Document No: LE03-01-SY23-127-
CBB-CoE-Fire-Tank-
Configuration.docx

**RE: State Significant Development Application (SSDA-69627466) - 3 Edison Lane,
Belmore - Fire Tank Configuration**

POTHOLE SITE PLAN
1:200

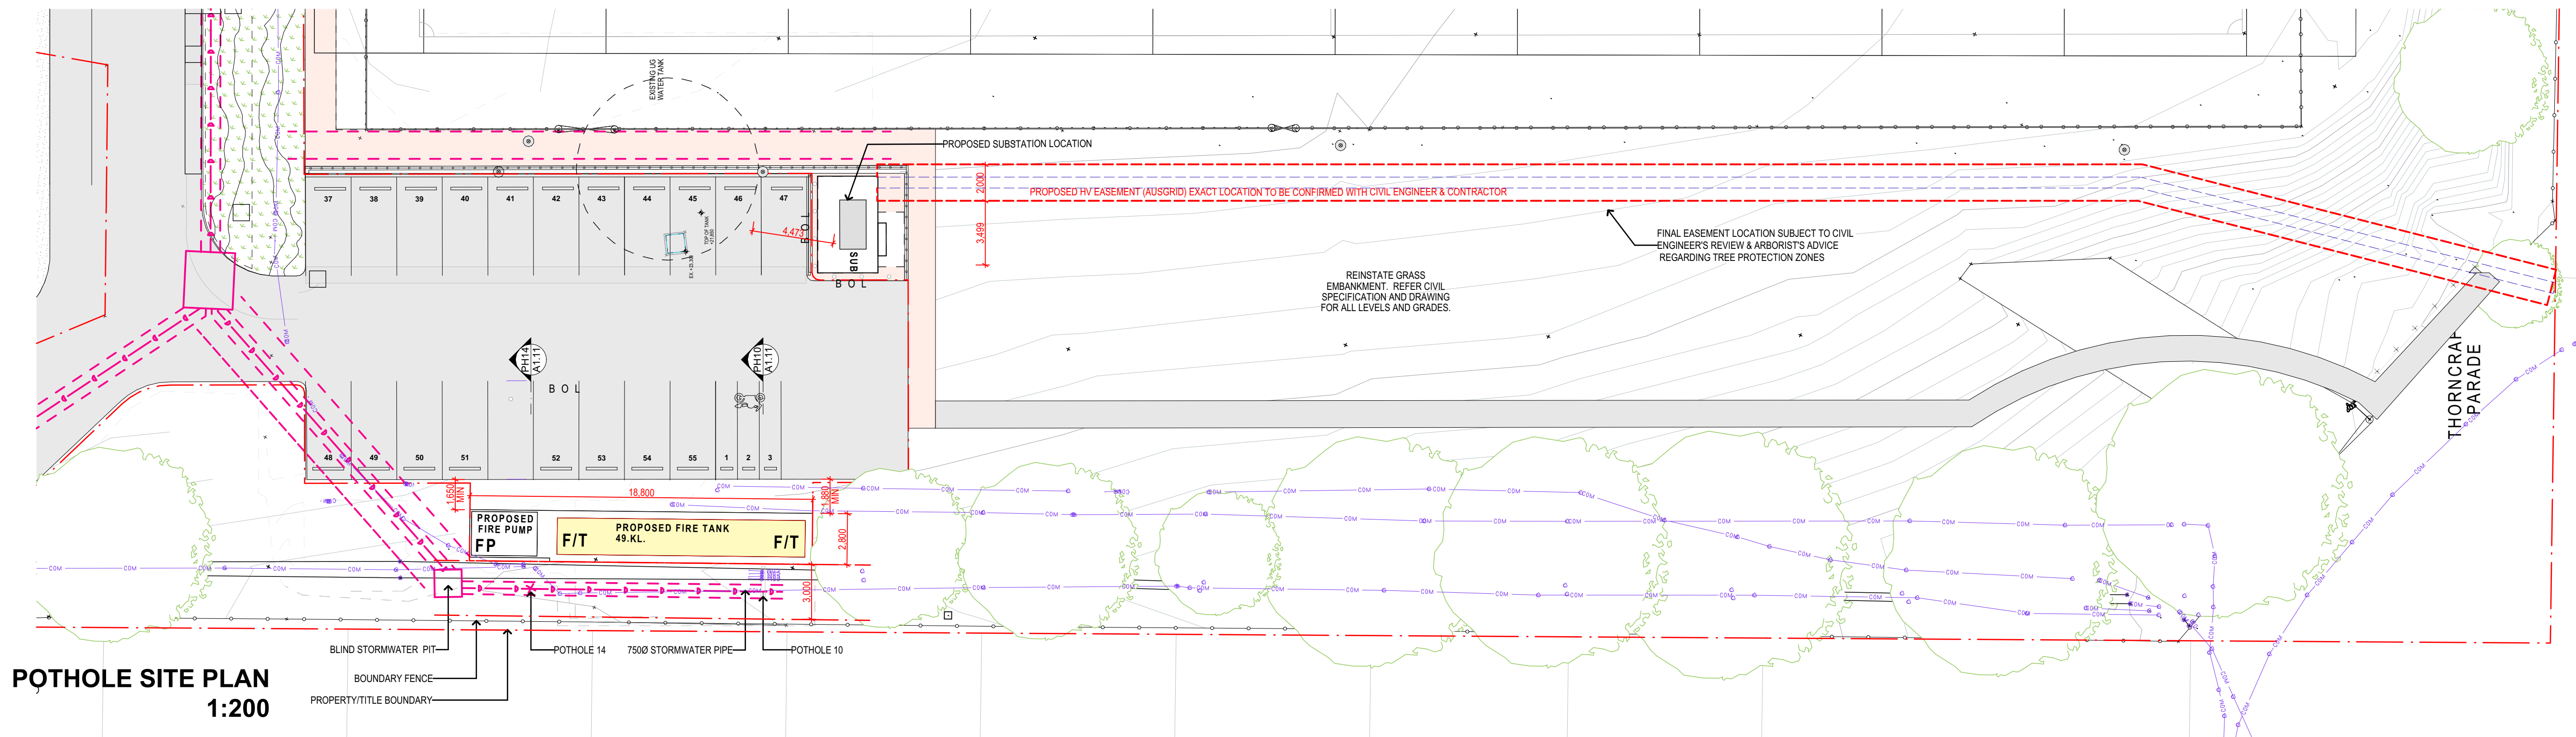
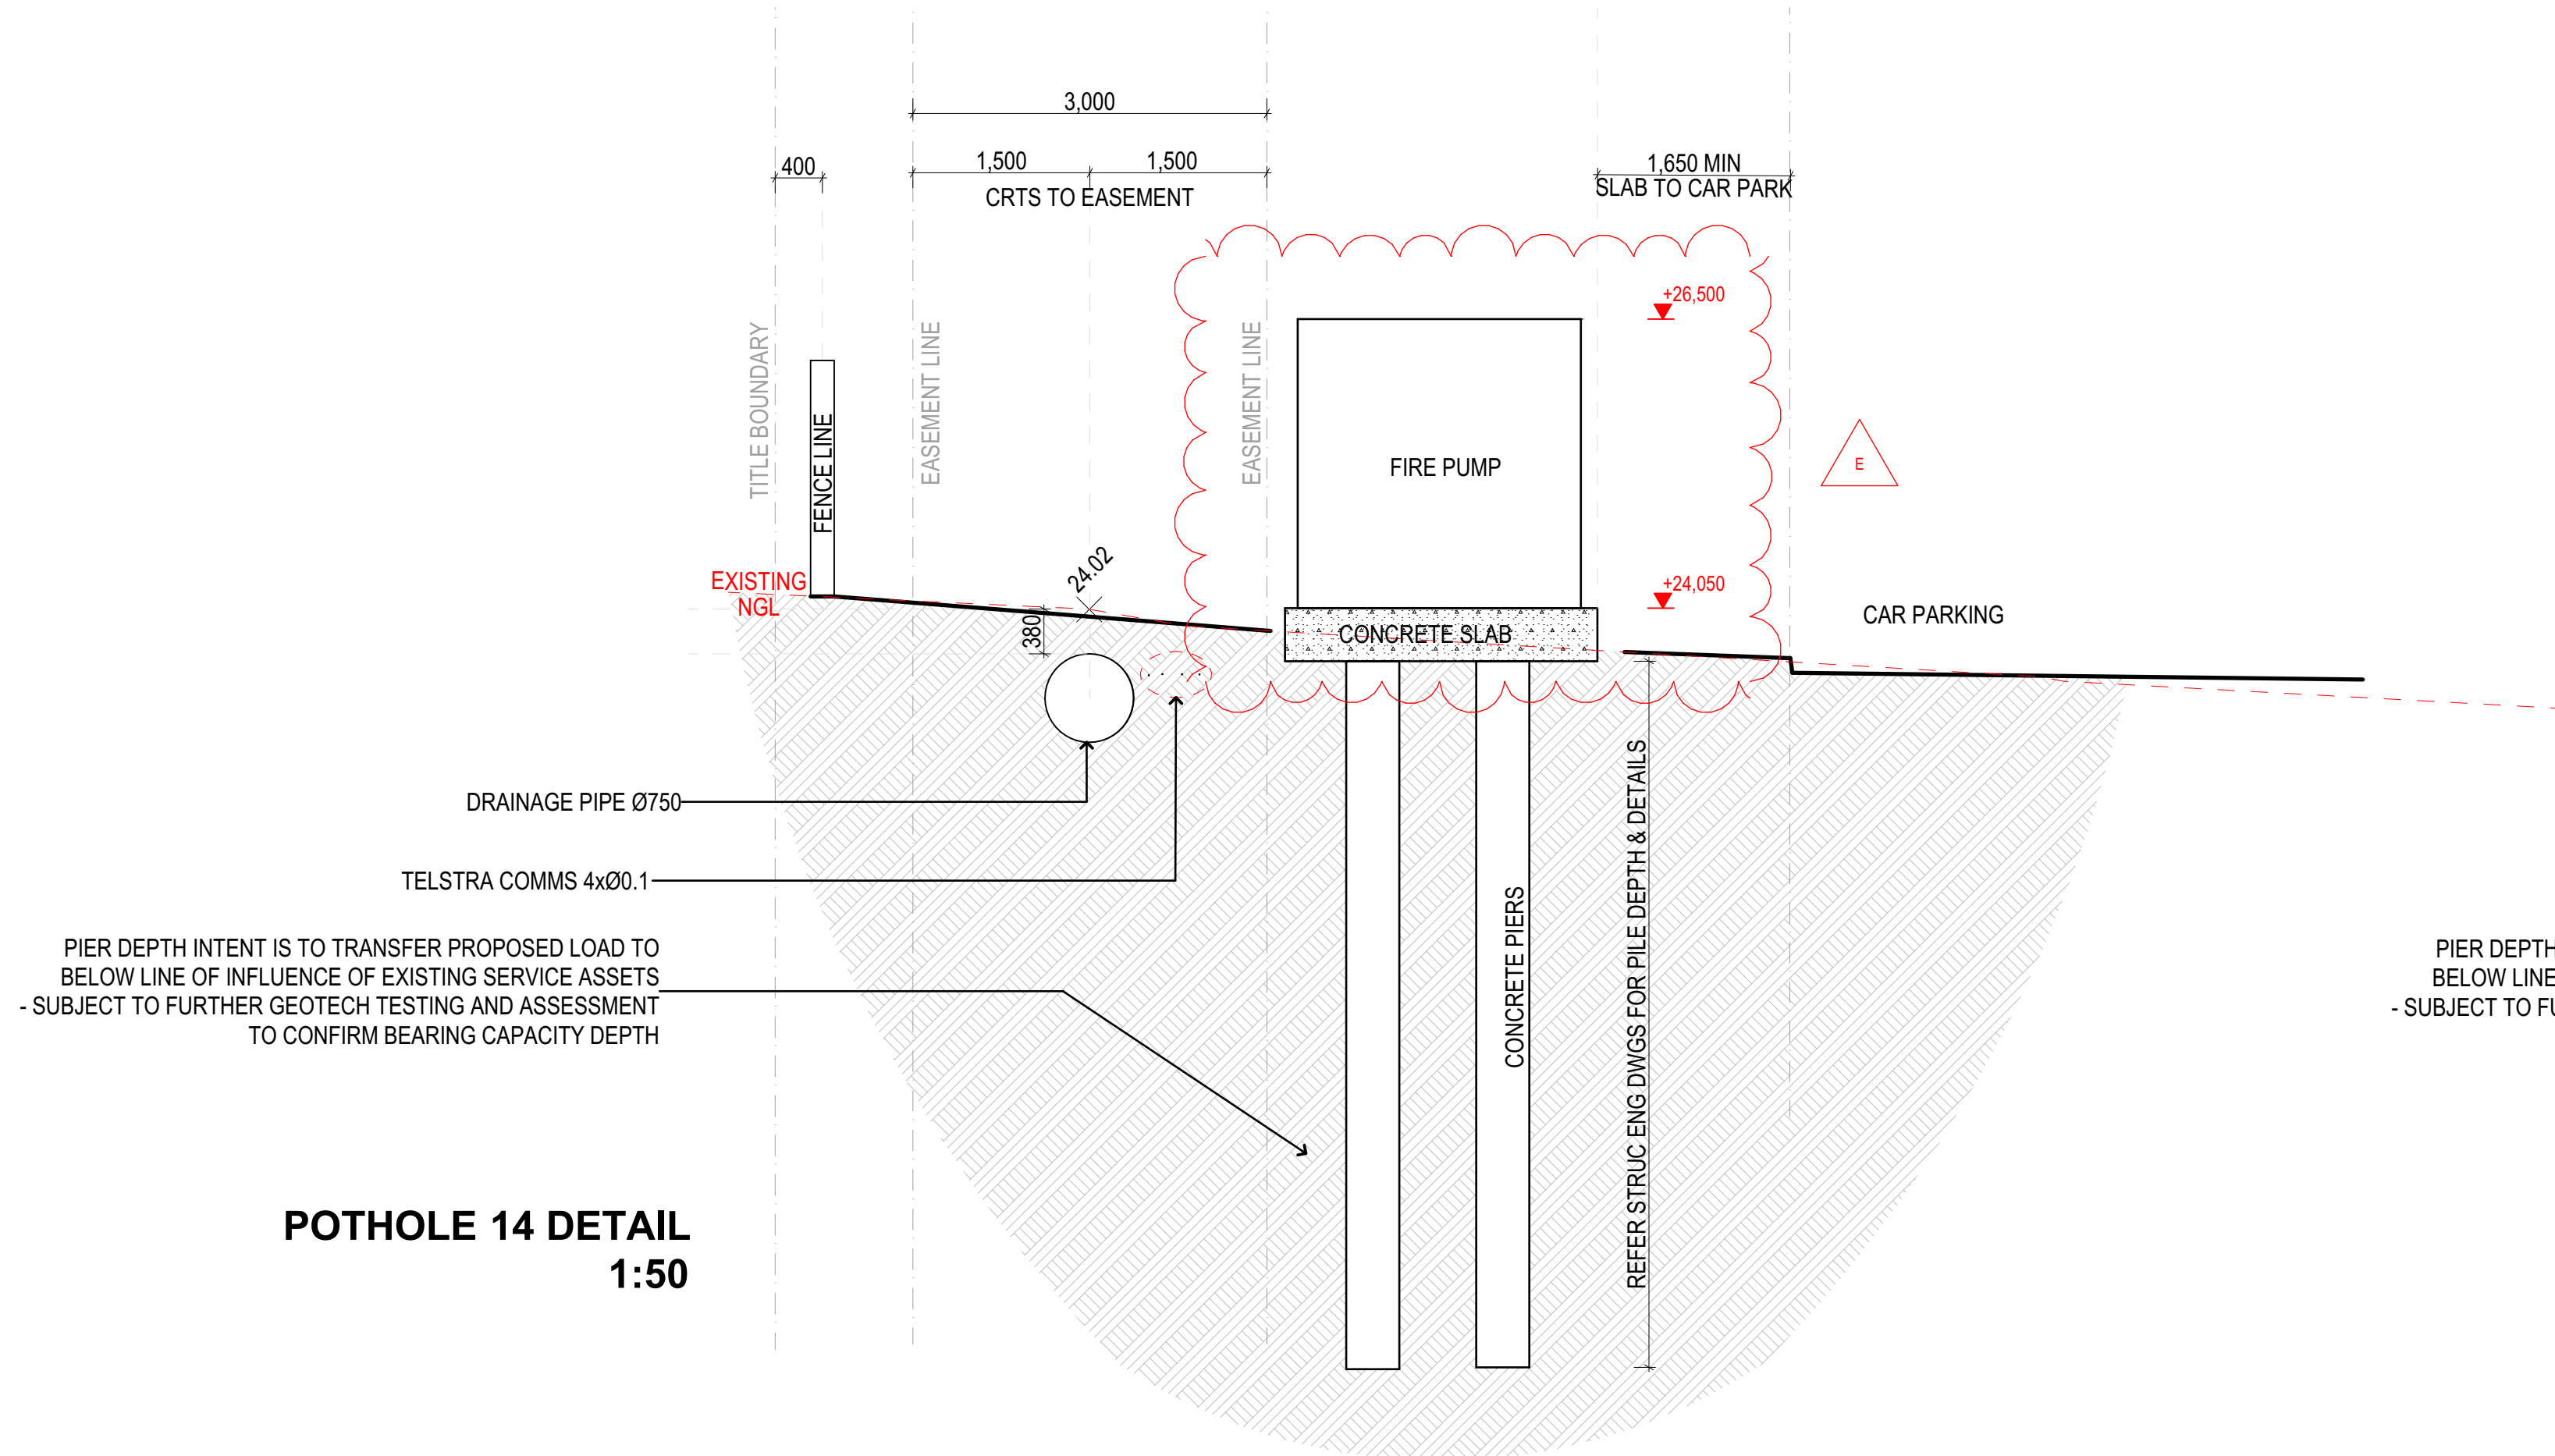
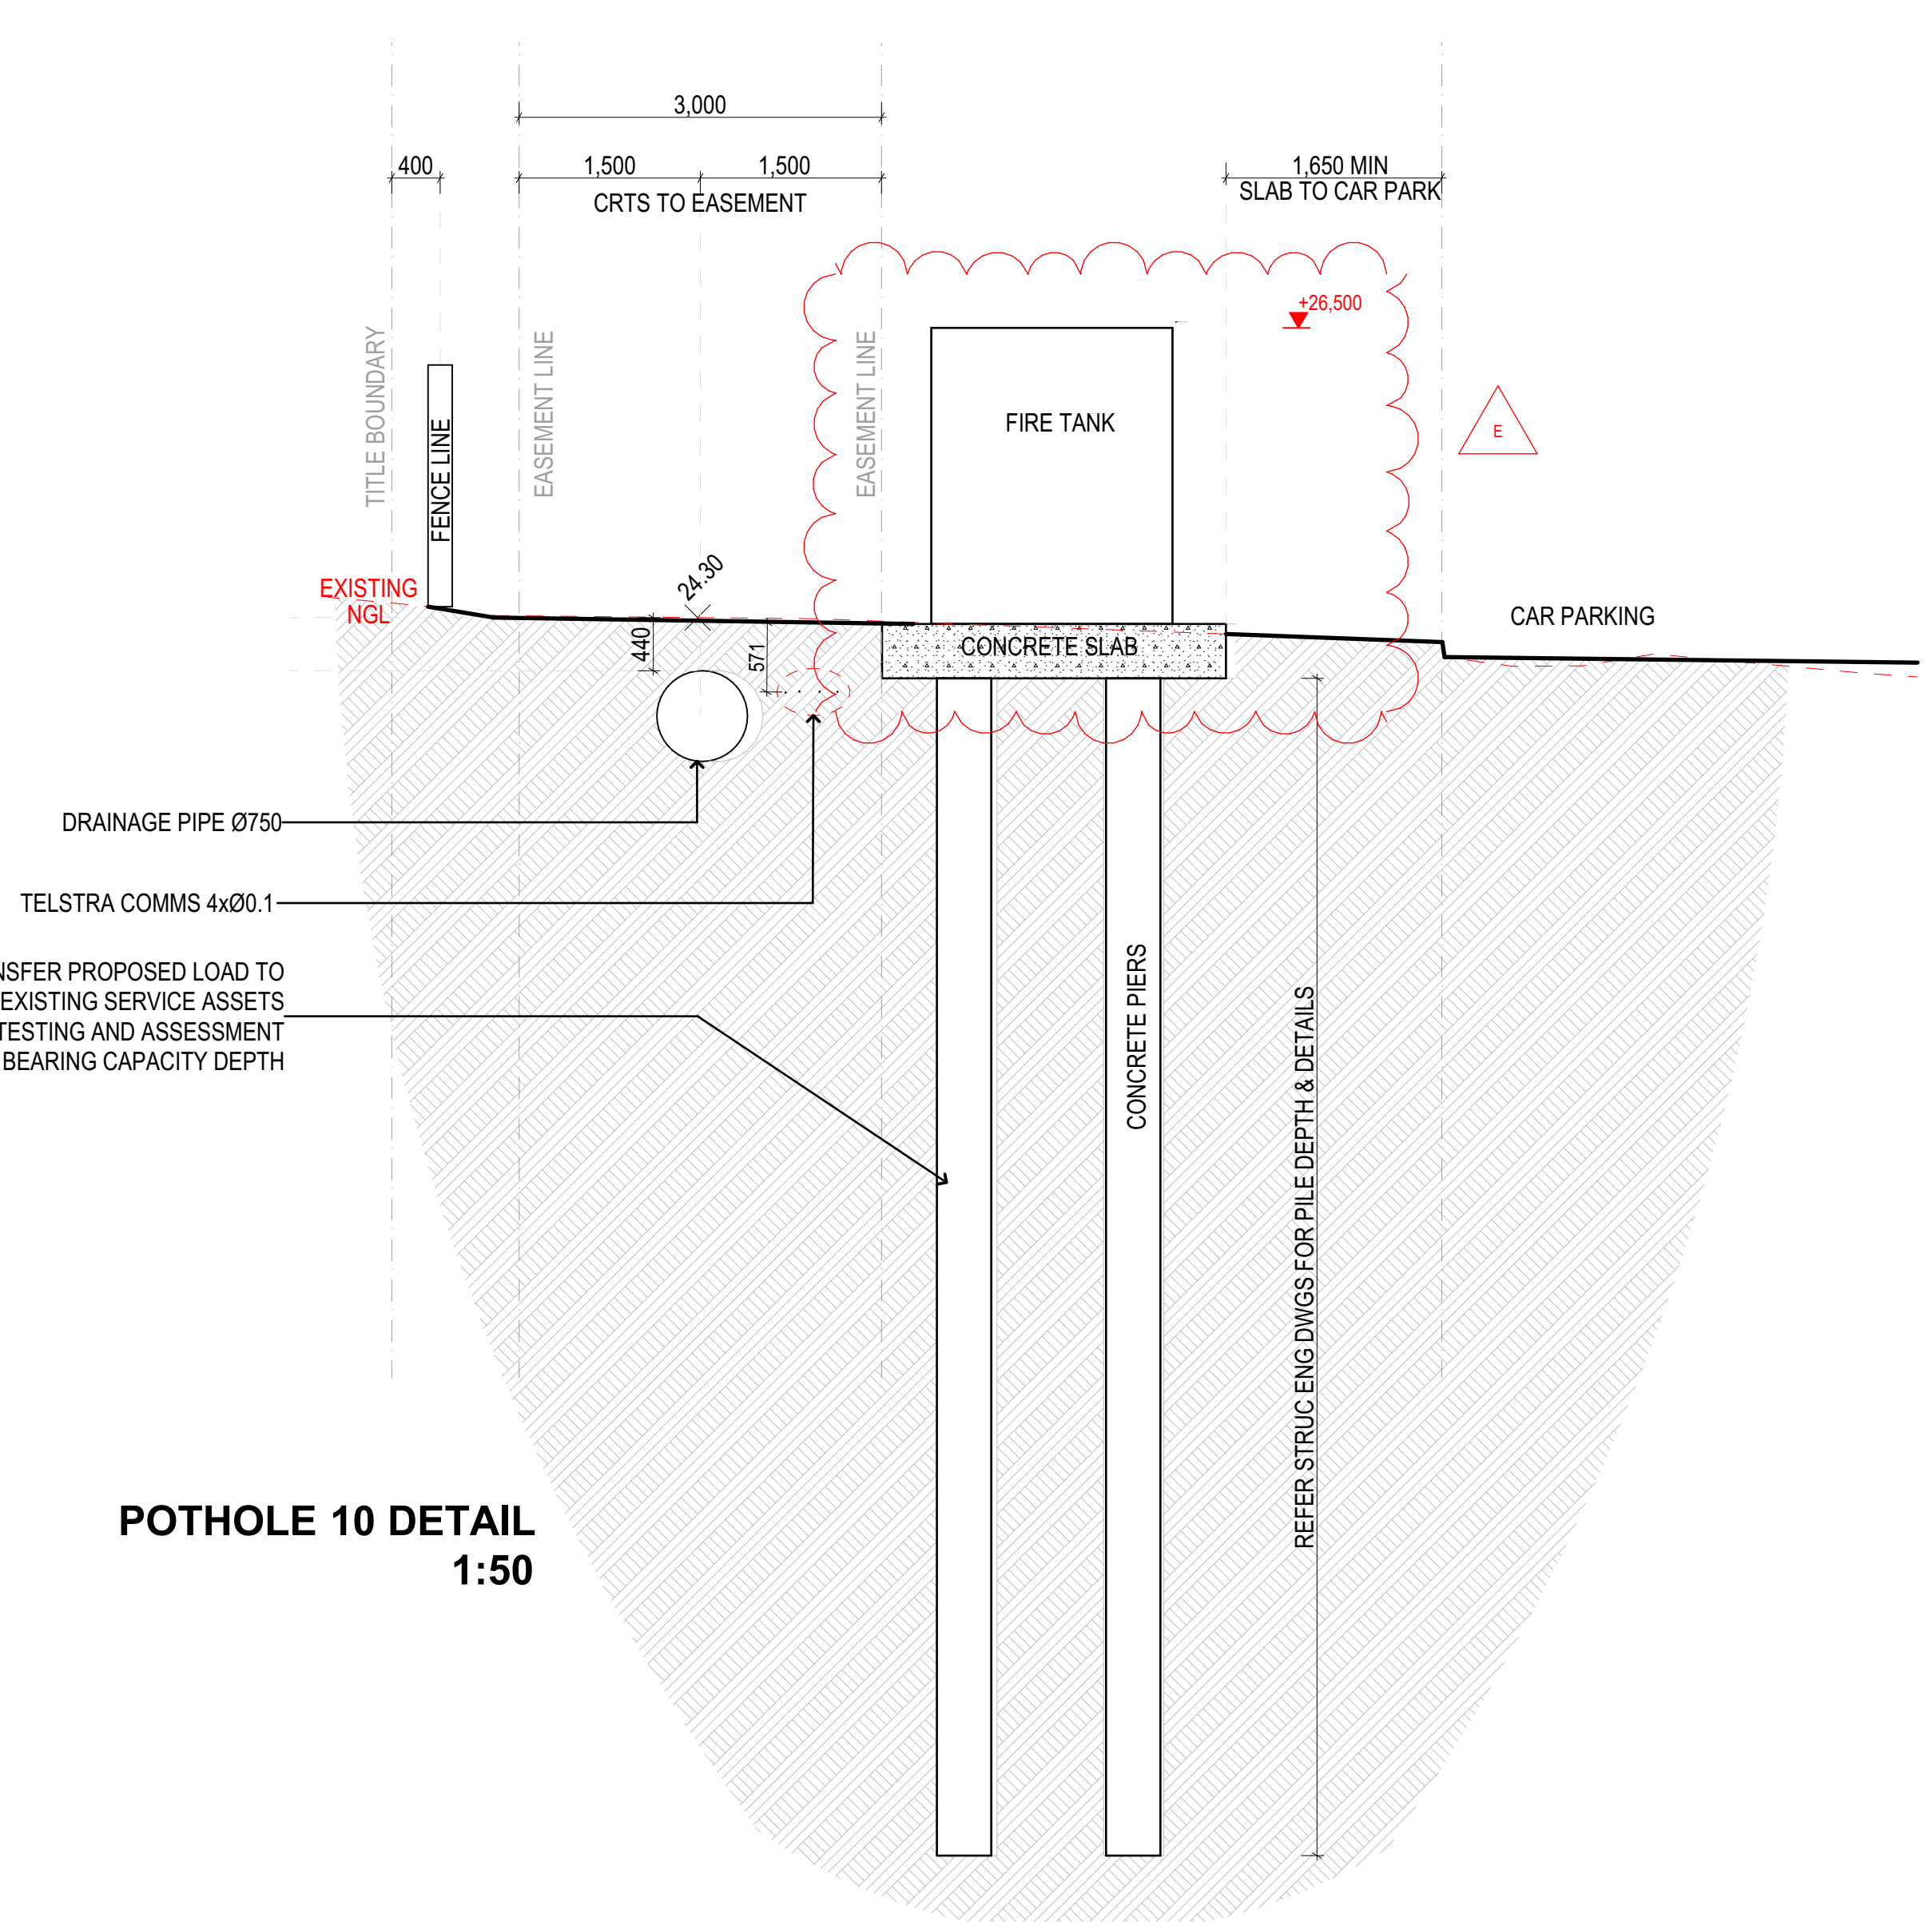
During detail design, an additional survey identified existing utilities which presented as a site constraint to where the fire tank is positioned. The constraints include cover to existing services, horizontal and vertical clearance and site levels.

Upon discovering an existing stormwater drainage line adjacent the proposed fire tanks, Council noted an 3m wide drainage easement is applied to the existing stormwater drainage. The drainage easement is not registered as part of the section 88B Instrument, thus impacting the configuration during detail design. The 3m drainage easement requires no footprint encroachment from the fire tank, to achieve compliance a rectangular shape fire tank is proposed, see **Figure 3**.
